From: Finlay Gardner <Finlay.Gardner@arun.gov.uk>
Sent: 13 July 2021 13:59
To: Planning.Responses <Planning.Responses@arun.gov.uk>
Cc: Daniel Vick <Daniel.Vick@arun.gov.uk>
Subject: FW: BE/59/21/PL

SITE PLAN - SHOWING VISIBILITY SPLAYS
1:500 SCALE (at A3)

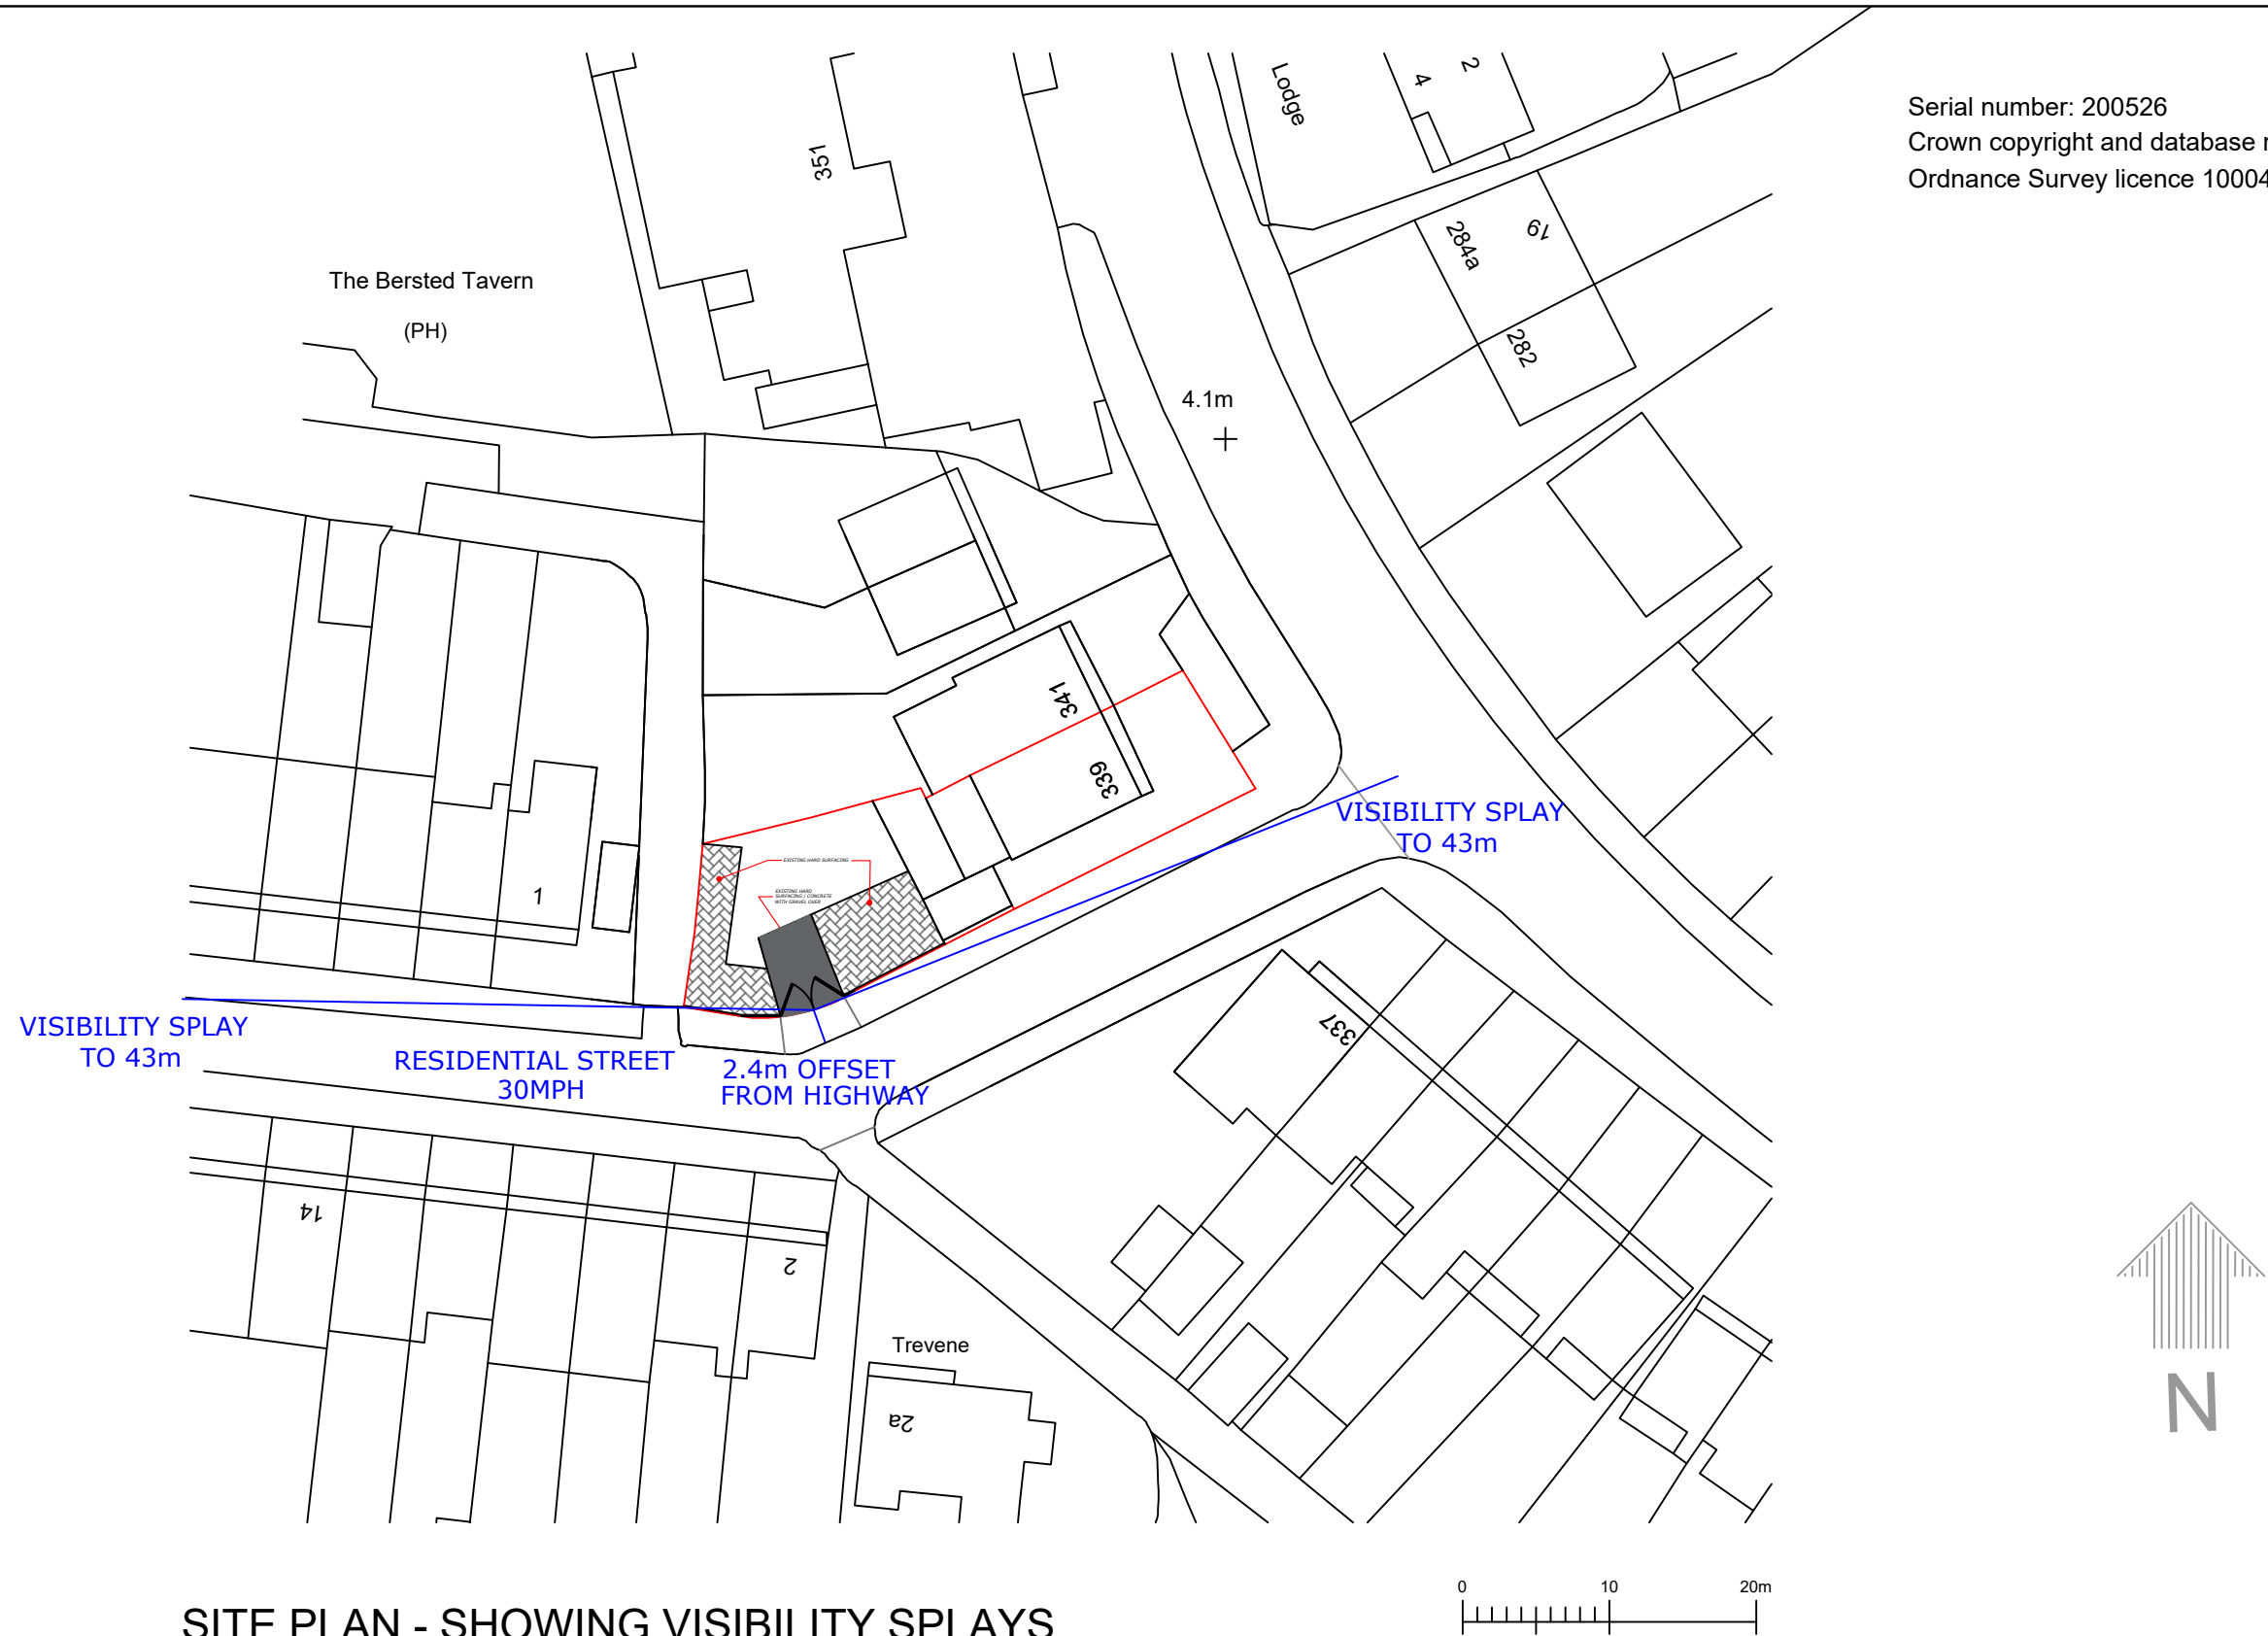
1. What is the height of the fence that has been put in place of the existing cement boarding?

The proposal is for a replacement 6ft high close board timber fence (as per image submitted). This will be positioned so as not to interrupt the visibility splays as required for the proposed access.

- As previously stated, the proposed access will serve the property 339 Chichester road only and will not be used by 'Delaney Plumbing' as stated in several objections. Should ADC wish to restrict or limit the use of the access in this regard then we would not raise issue with such a planning condition.
- The plans provided reflect the proposed layout based on OS survey data and site measurements. As such they do not reflect the exact position or location of the temporary gated access onto the property, rather they reflect the proposed location in order to achieve required visibility splays.
- It is my understanding that in permitting the cross over last year WSCC Highway Authority required the access to be precisely located on the corner of the site in order to achieve the required visibility splays.

The blockwork wall has been temporarily replaced with timber hoarding to a height of 6ft to secure the site on the boundary with the public highway.
